Re: Professional Engineer's Certification of Permanent Control Measure
Flying Horse North Filing No. 4, Pond C

This letter serves as a Pond Certification for the constructed Full Spectrum Detention Facility "Pond C" located in Flying Horse North Filing No. 4. The permanent control measure is located at the central east area of the subdivision, adjacent and north of Old Stagecoach Road, east of Fringe Place and west of Rubble Drive.

A Stormwater Preliminary Acceptance Punchlist was issued by El Paso County Stormwater Engineering staff and inspections dated 6/11/2026 for a 1st Walkthrough dated 6/11/2026 for ESQCP No. ESQ258 with the related PCD File Nos. SF2422, CON258, and ASB2616.

DRAWN BY: CMD JOB DATE: 12/5/24
 APPROVED: RDL JOB NUMBER: 211030.240
 CAD DATE: 8/19/2024
 CAD FILE: J:\2021\211030\CAD\Drawings\Filing_No_4\Pond_C_Grading

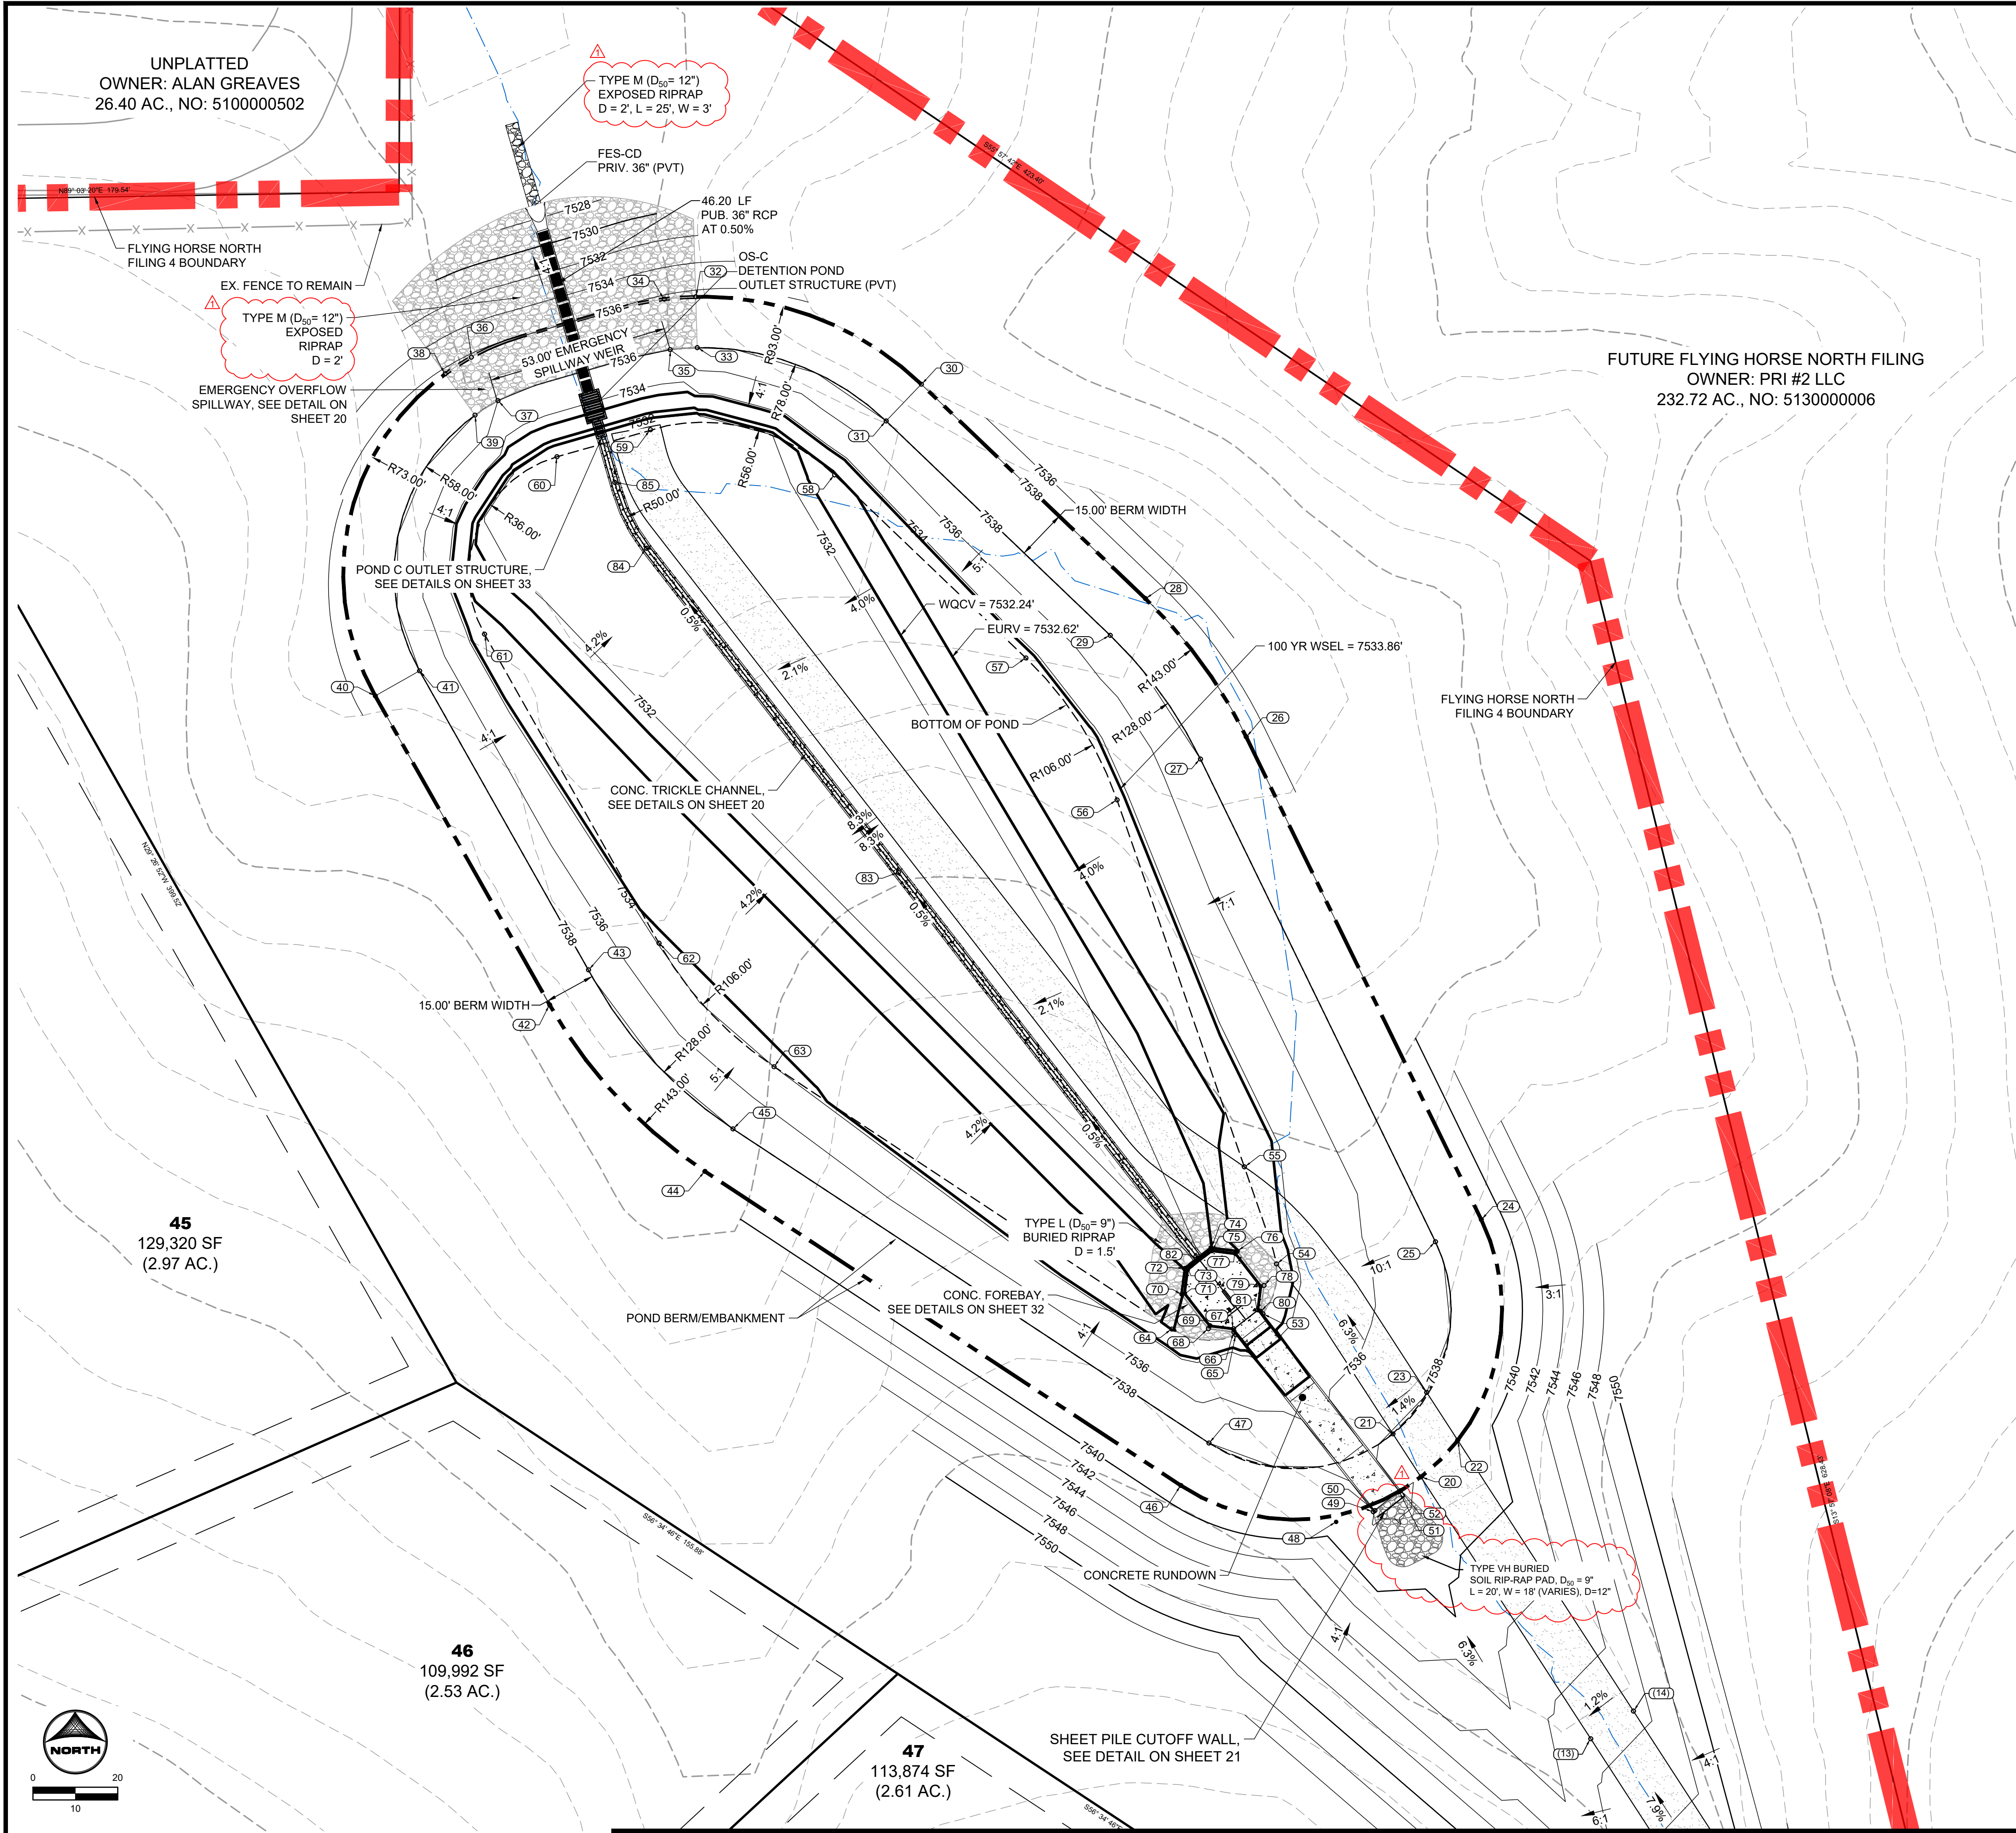
- Inflow Riprap Upstream of Forebay
 - Riprap at the forebay inflow is not shown on the approved plans. Consult the Engineer of Record and provide supporting documentation as needed. See Note 1. **As-built redlines have added this condition.**

- Outfall Riprap
 - Riprap at the pond outfall is not installed per the approved plans. Plans show buried riprap and in the field it is installed as exposed riprap. Install per approved plans or consult the Engineer of Record. See Note 1. **Outfall/spillway rip-rap is exposed rip-rap and is now reflected on**

- ***the as-builts, as approved by the Engineer of Record.***
 - Also, the riprap apron is not shaped to convey flows. It is piled up such that there is no positive drainage and flows will just bypass the riprap and cause erosion. So please reconfigure riprap to properly convey flows. ***A more defined conveyance V-shape swale has been constructed.***
- Maintenance access road installed with crushed concrete, which per direction from CDPHE is not an acceptable means of Final Stabilization, nor was that material on the approved plans, so please remove and install access road material per plans. ***As-built plans and redlines now call out crushed concrete as approved by the Engineer of Record. This was discussed with Stormwater staff in July 2026 and is to be allowable for this filing.***
